27 November 2024
Document No. 60.01029.01 LTR1D1.DOCX

Consultant Advice Notice (DRAFT)
102 Wyndam Street, Alexandria, NSW
Noise & Vibration Review - New Health Research Facility (SSD-63067458)

The Project has been submitted to the Department of Planning, Housing and Infrastructure under the application: SSD-63067458. The Environmental Impact Statement (EIS) for the Project includes a Noise and Vibration Impact Assessment (NVIA) as Appendix BB of the report. This review is focused on the NVIA prepared for the Project EIS.

Attachment 4a - Basement Cross Section (North-South)

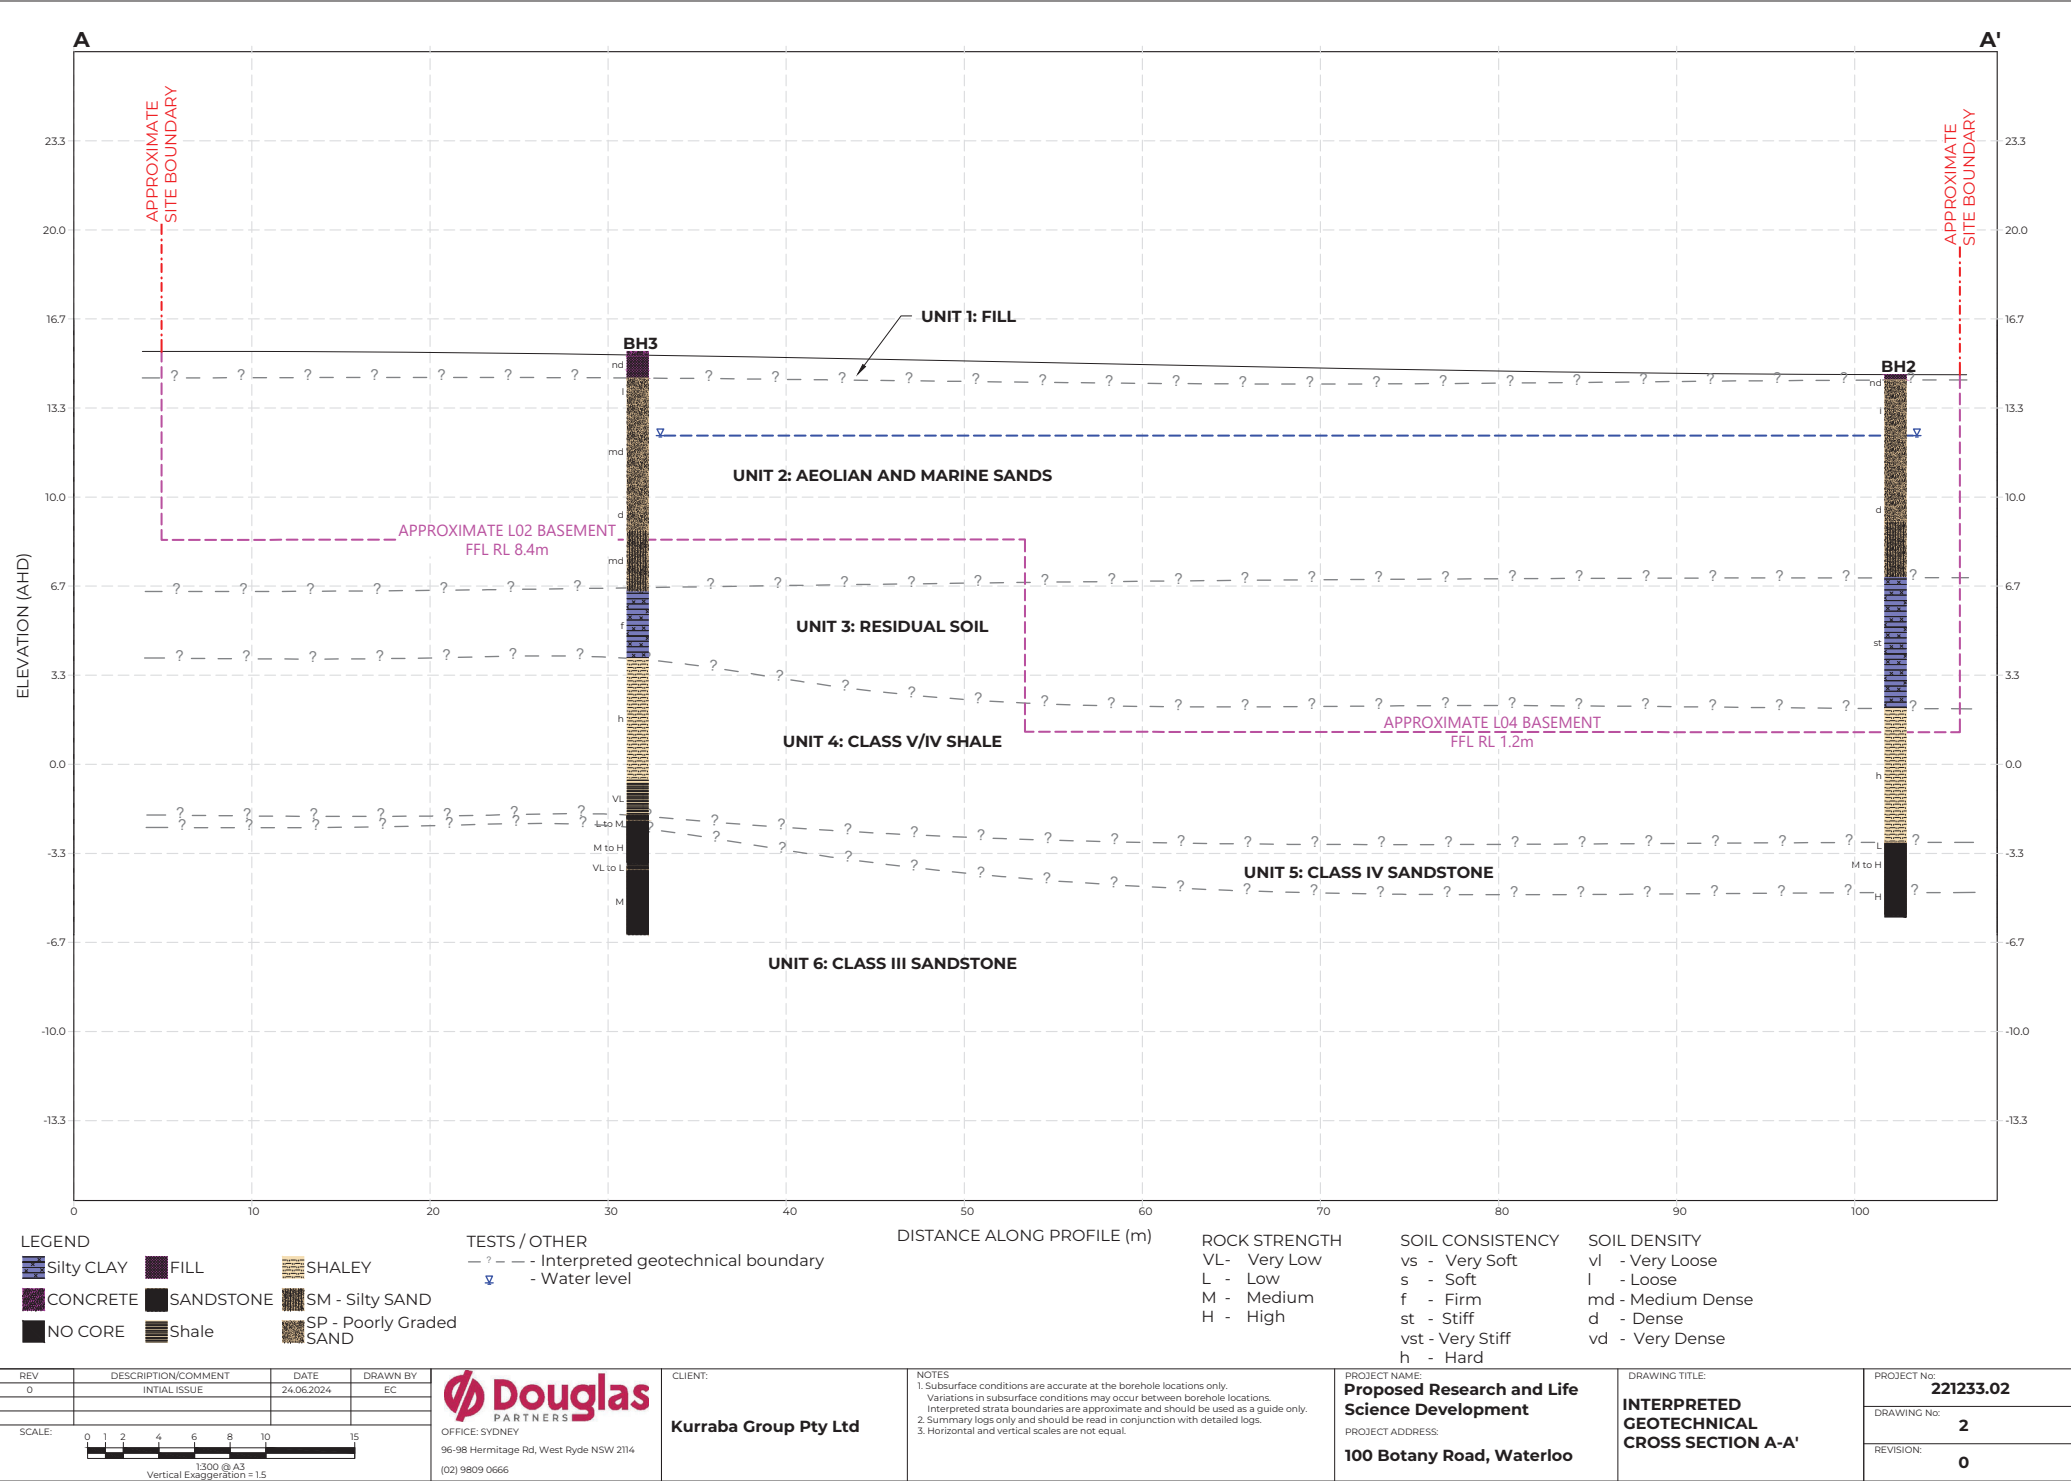
Figure 3 above shows that the excavation of the basement levels will be within 1 – 2 m of the 102 Wyndam Street building facades. Excavators with hammers can generate high vibration levels at this distance. It is not unusual to see vibration levels in excess of cosmetic damage criteria and possibly structural damage criteria if shared structural foundations between buildings are impacted by the machines.

Why does the NVIA report not predicted ground borne vibration and structure borne noise levels at the nearest affected receivers to the basement excavation?

The NVIA should report the construction vibration levels, durations of impacts and provide suitable mitigation measures as per the guidance in *Assessing Vibration: A Technical Guideline (DEC 2006)*.
